April 26, 2023

MEMO

RE: 2165 Cane Mills Road - Coats, NC
Project No: IN022412

2ND FLOOR/CEILING FRAMING PLAN

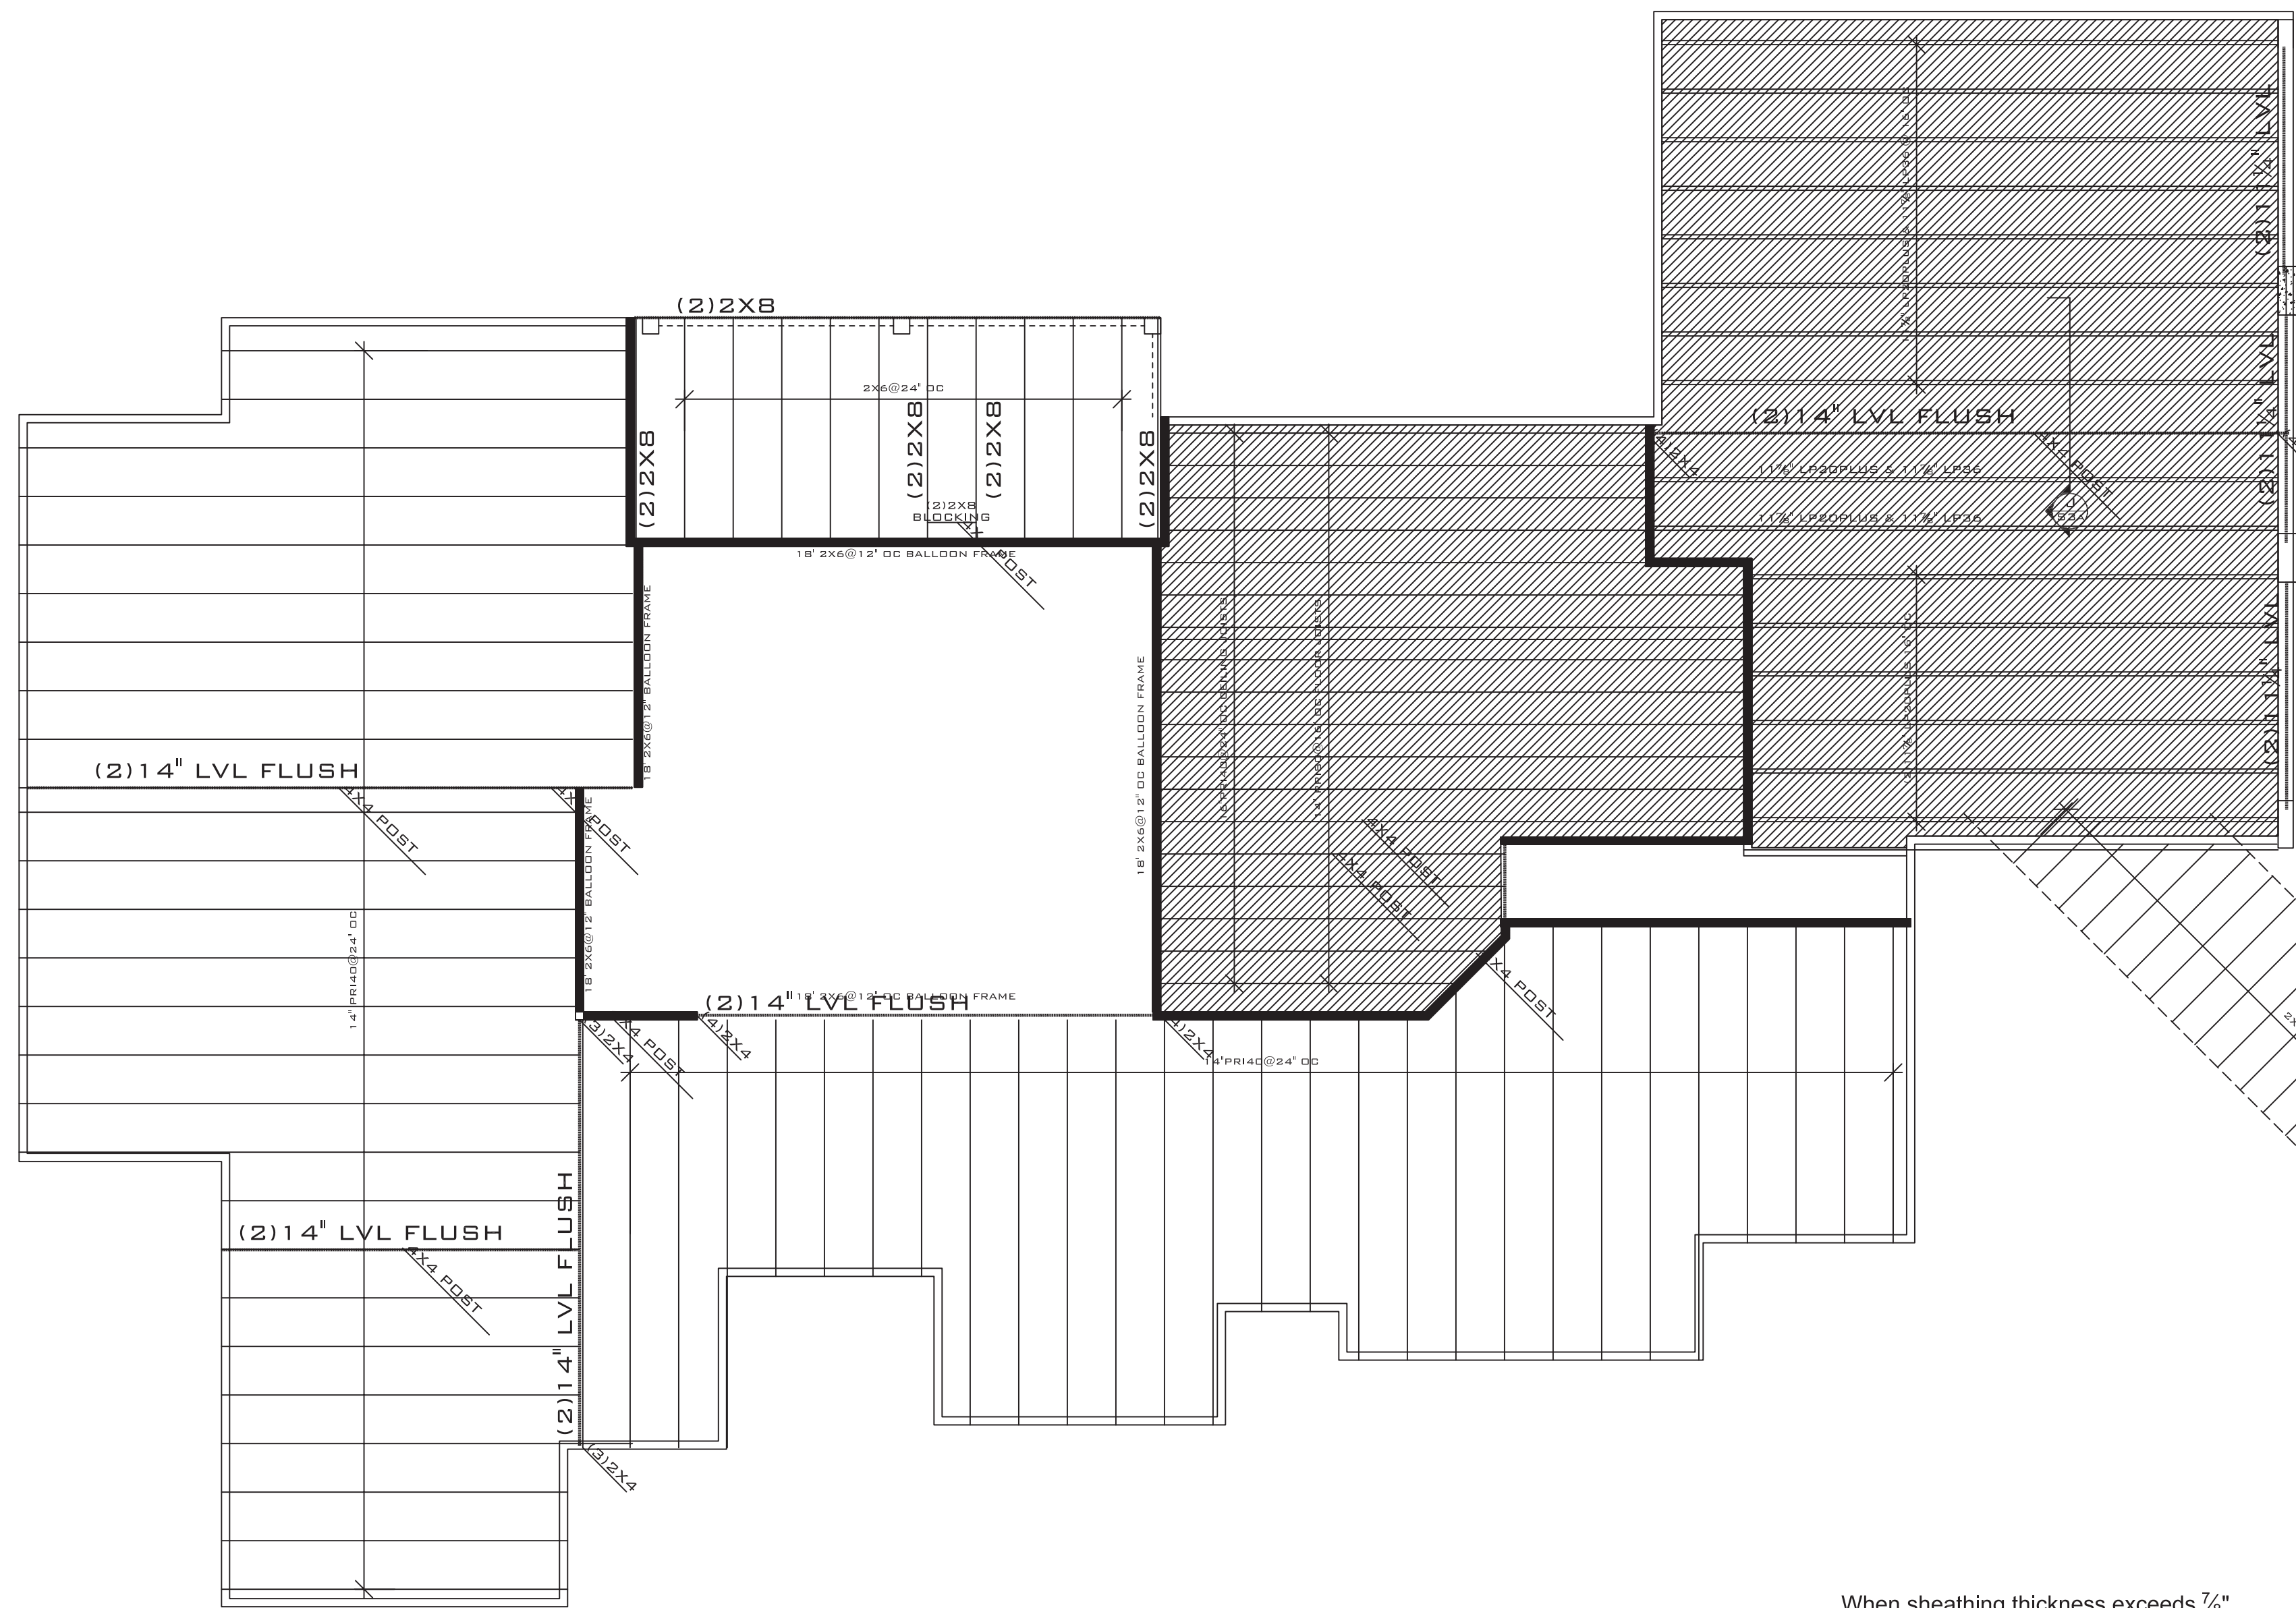
The 11 7/8" NI 80 I joists have higher structural properties than the LP36 I joist specified and are therefore an acceptable for use.
